CITY OF ALBUQUERQUE

**Re: American Toyota
5995 Alameda NE
90-Day Temporary Certificate of Occupancy- Transportation Development
Engineer's Stamp dated 12-18-14 (C18D012)
Certification dated 6-2-17**

**SITE PLAN**

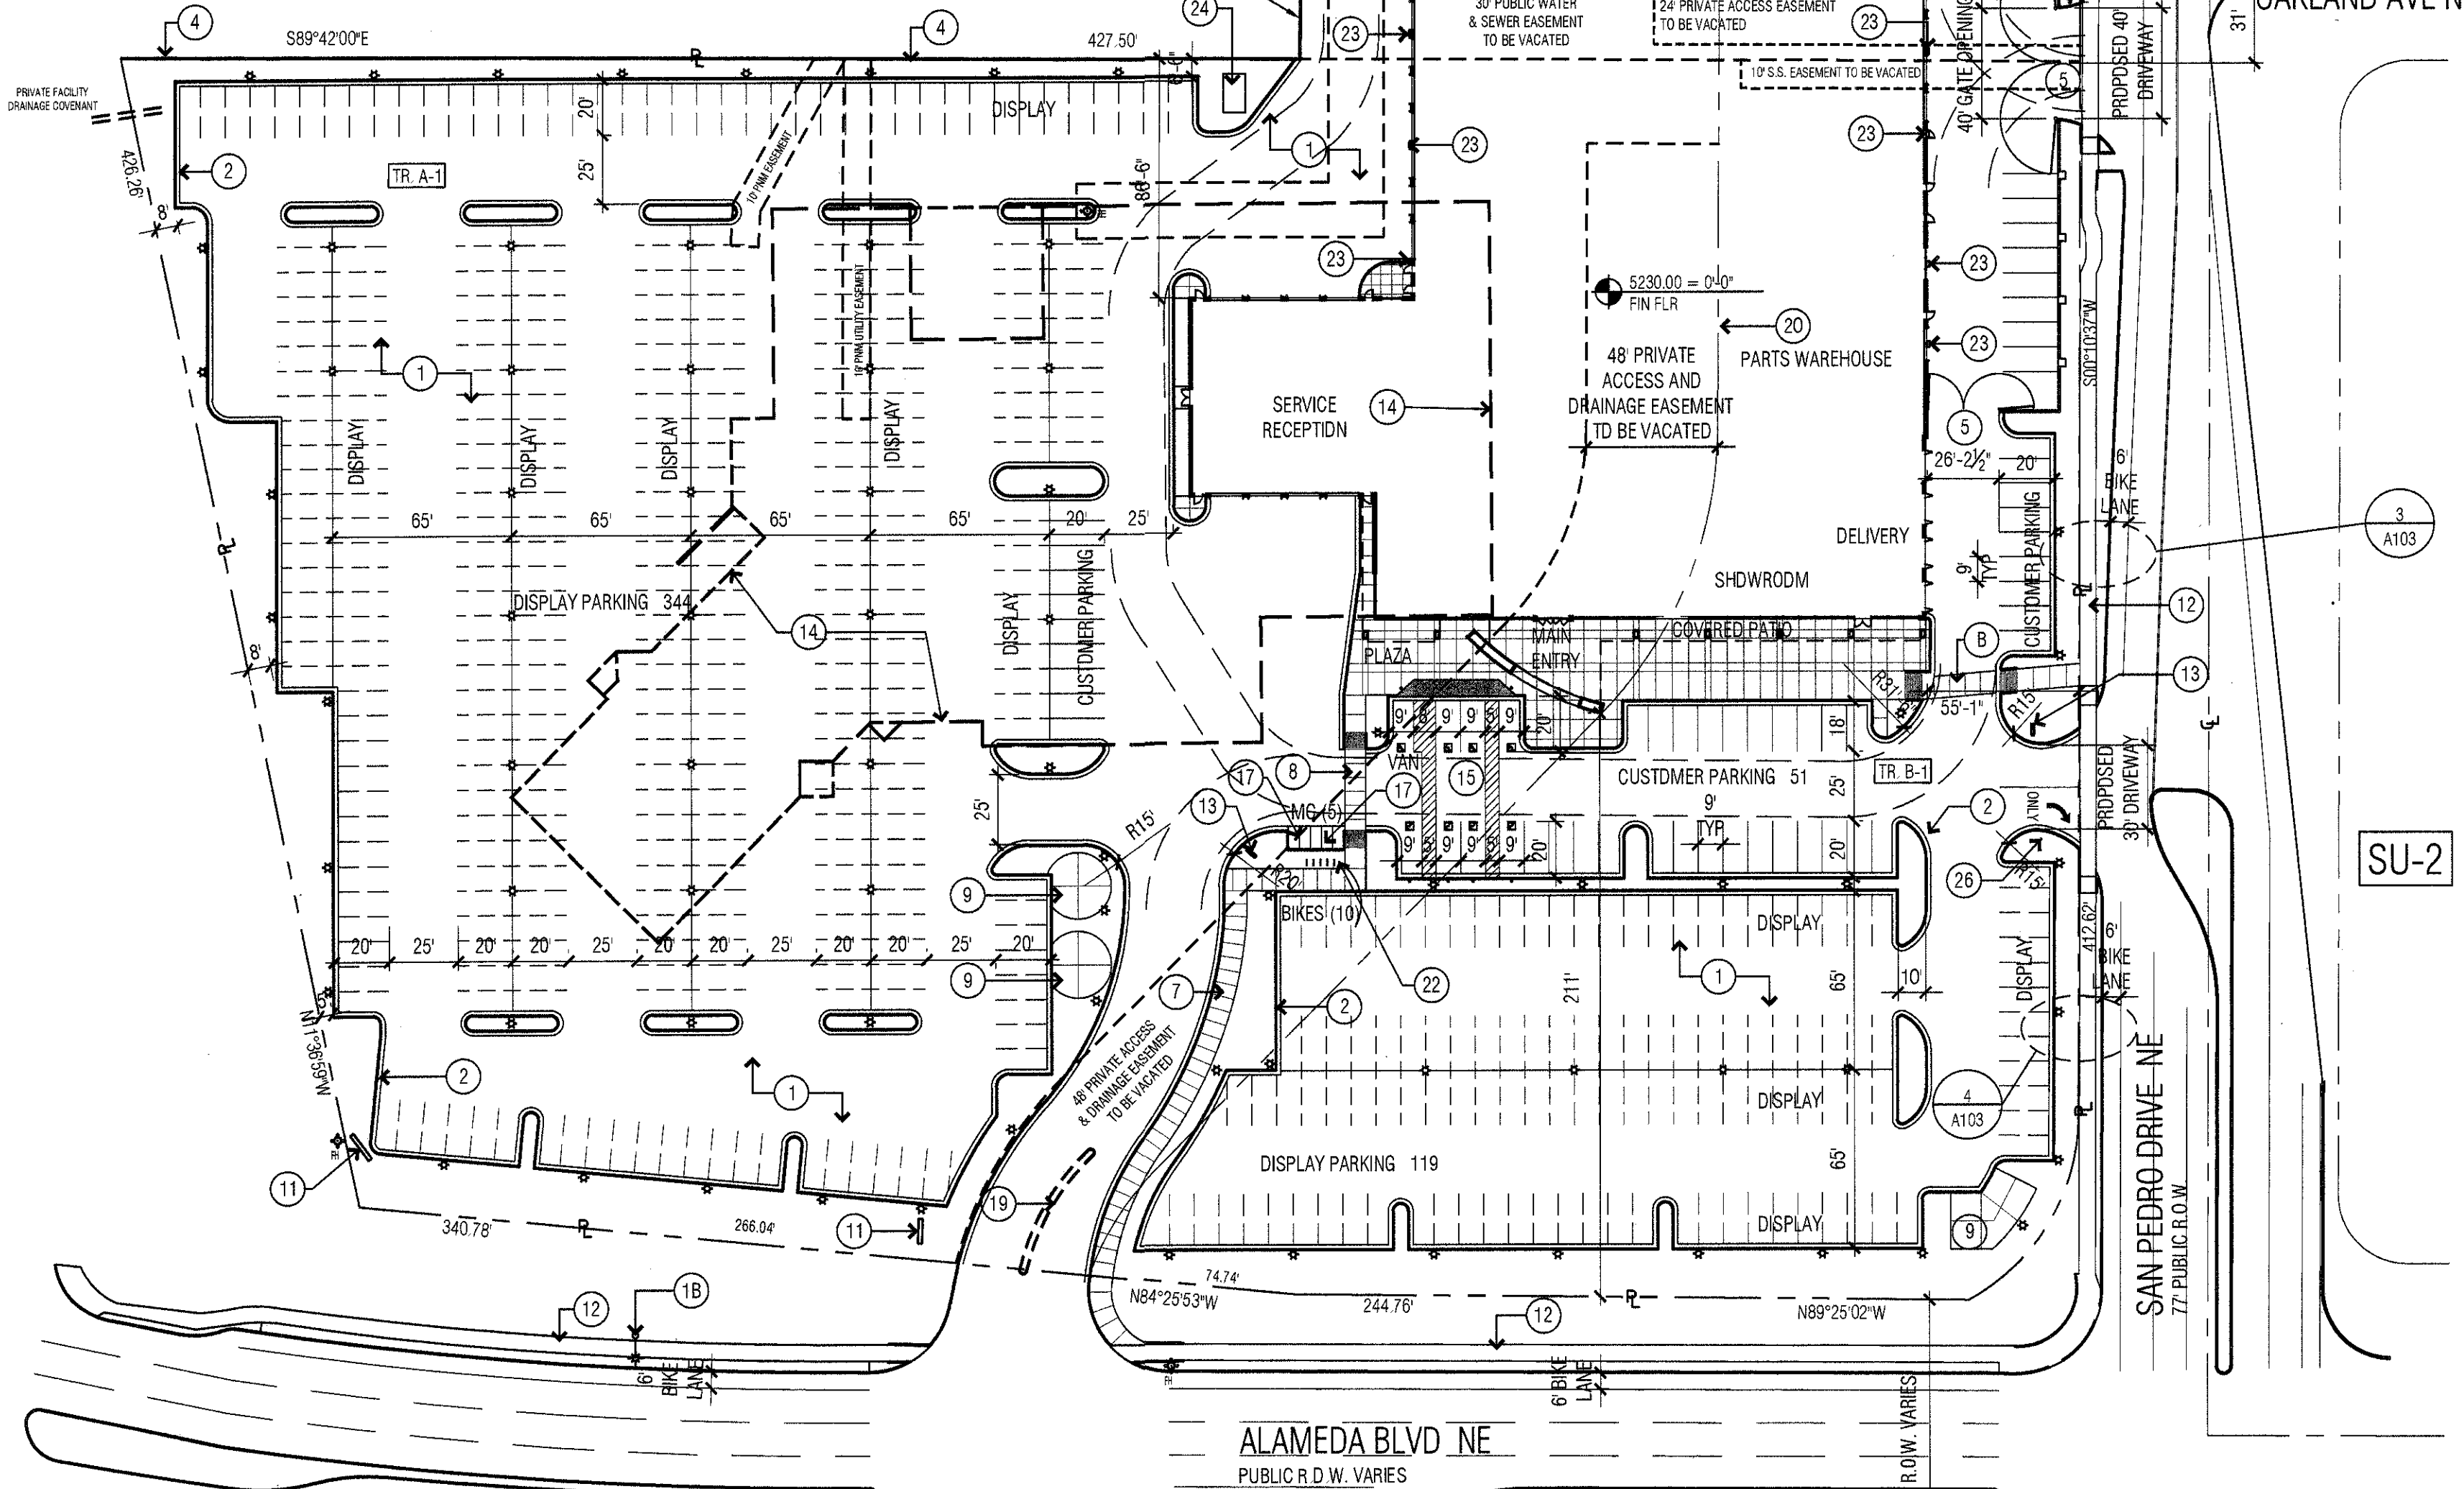
1. The ADA accessible parking sign must have the required language per 66-7-352.4C NMSA 1978 "Violators Are Subject to a Fine and/or Towing." Please call out detail and location of HC signs.
2. The ADA access aisles shall have the words "NO PARKING" in capital letters, each of which shall be at least one foot high and at least two inches wide, placed at the rear of the parking space so as to be close to where an adjacent vehicle's rear tire would be placed. (66-1-4.1.B NMSA 1978)
3. All crates and constructions equipment must be removed prior to permanent CO.
